A57 Link Roads Case Team
National Infrastructure Planning
Email: a57linkroads@planninginspectorate.gov.uk

13th October 2022

A57 LINK ROADS DETERMINATION - SECRETARY OF STATE'S REQUEST FOR COMMENTS FROM THE APPLICANT AND ALL INTERESTED PARTIES

| FIGURE 5.2<br>AIR QUALITY MODEL SENSITIVE RECEPTORS<br>SHEET 2 OF 17 |                |               |        |

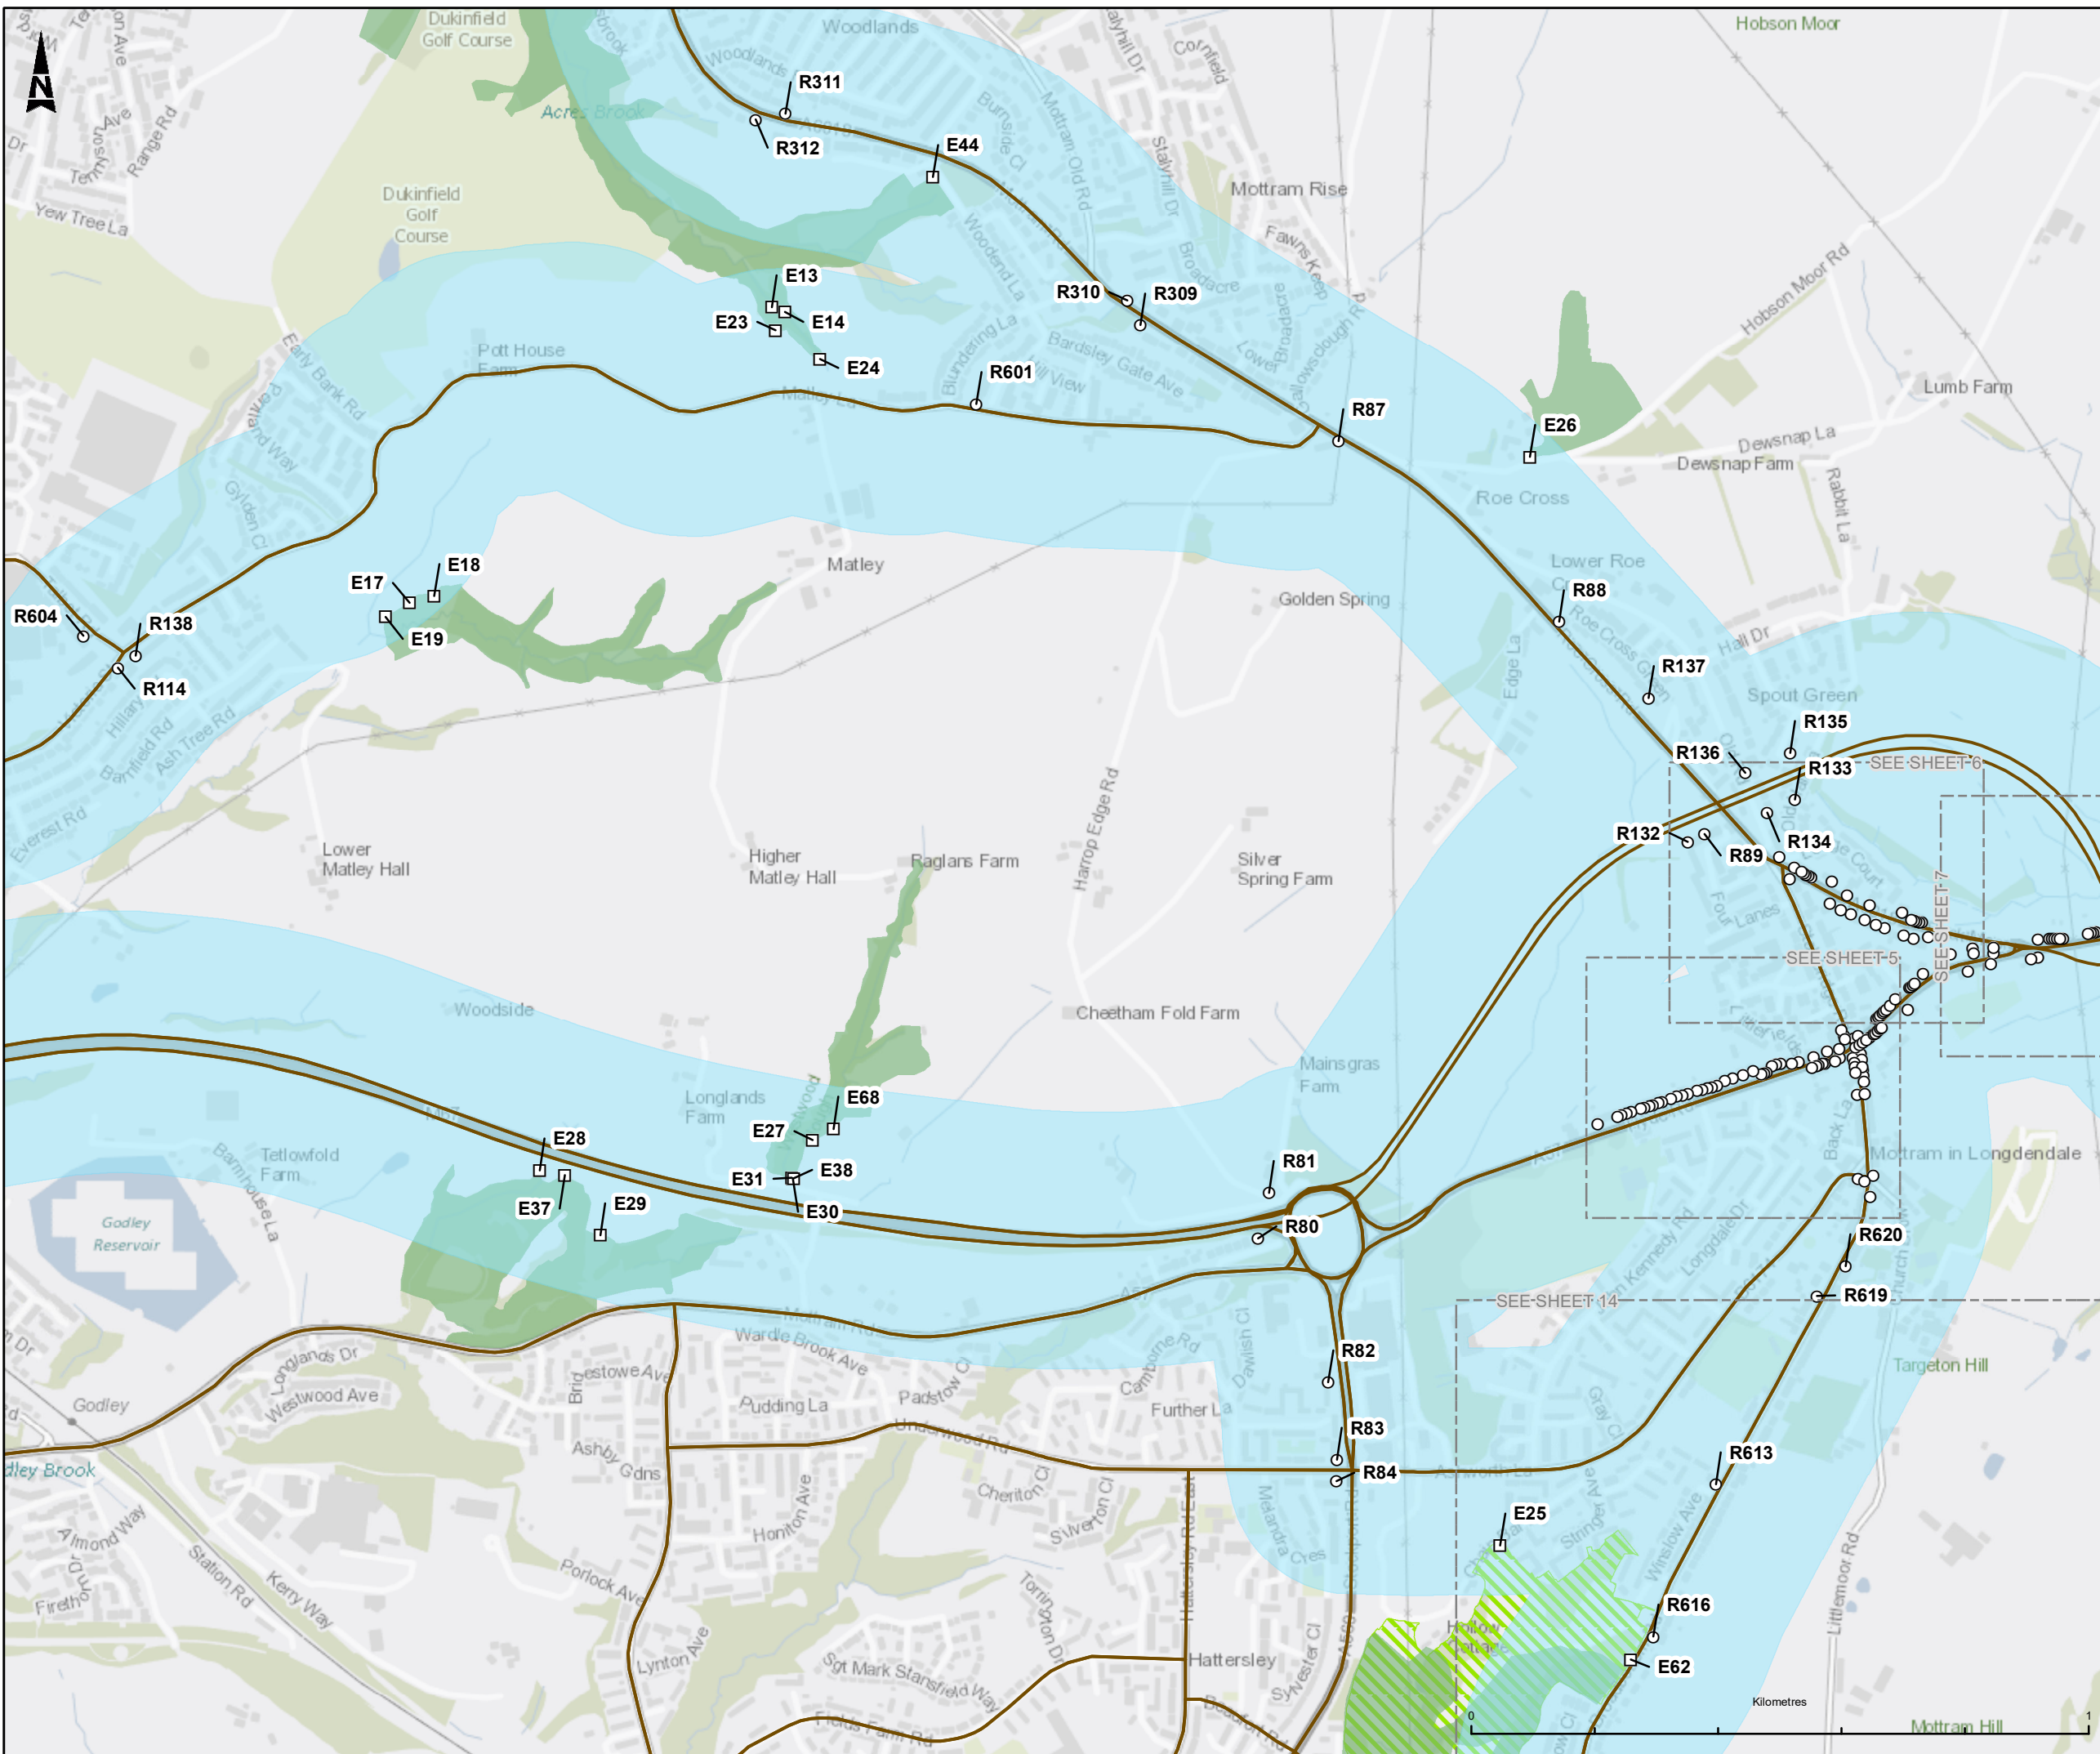
As we demonstrated throughout the Examination the assessment of air quality by the Applicant is compromised by the enormity of the problems with the traffic modelling. These are summarised in a letter from ten Interested Parties [REP10-017, pp 1-6]. With respect to air quality assessment the traffic model was refined to alter the distribution of traffic within Glossop, and through Tintwistle [REP2-090 pdf page 519-521/790, paras 7.3.1 and 7.3.2, Figure 7-1]. This refinement was made specifically to avoid air pollution effects of the scheme that could '*jeopardise the application for development consent. Changes in traffic flow and speed as a result of the scheme were predicted to cause exceedances of the AQ strategy objectives for annual mean nitrogen dioxide (NO2).*' The three locations where air pollution could jeopardise

development consent are within the Tintwistle AQMA, within in the Dinting Vale AQMA and on Glossop High Street West (REP2-090 pdf page 521/790, Figure7-1). The refinement led to these three locations no longer meeting the threshold for air quality assessment. The impact of the scheme on both AQMAs was not presented and there were no modelled receptors on High Street West¹. The local authority responsible for addressing air pollution, High Peak Borough Council, was still questioning the traffic model results with respect to air quality assessment at the end of the examination. Until there is confidence in the traffic modelling all its outputs are questionable, and the worst effects of the scheme are unknown/uncertain. The Secretary of State (SoS) can neither reach a reasoned conclusion on the significant effects of the proposed development on the environment under Regulation 21 of the 2017 Regulations (the EIA Regulations) nor fulfil the legal requirement to weight the adverse impacts of the scheme against its benefits (Planning Act 2008, s.104 (7)).

The traffic modelling and its application should be subject to independent assessment. Full technical dialogue with the assessors and all interested parties should be established to the satisfaction of all and in line with professional Codes of Conduct. Only full challenge and scrutiny of the model will enable all parties to have confidence that the model outputs are robust.
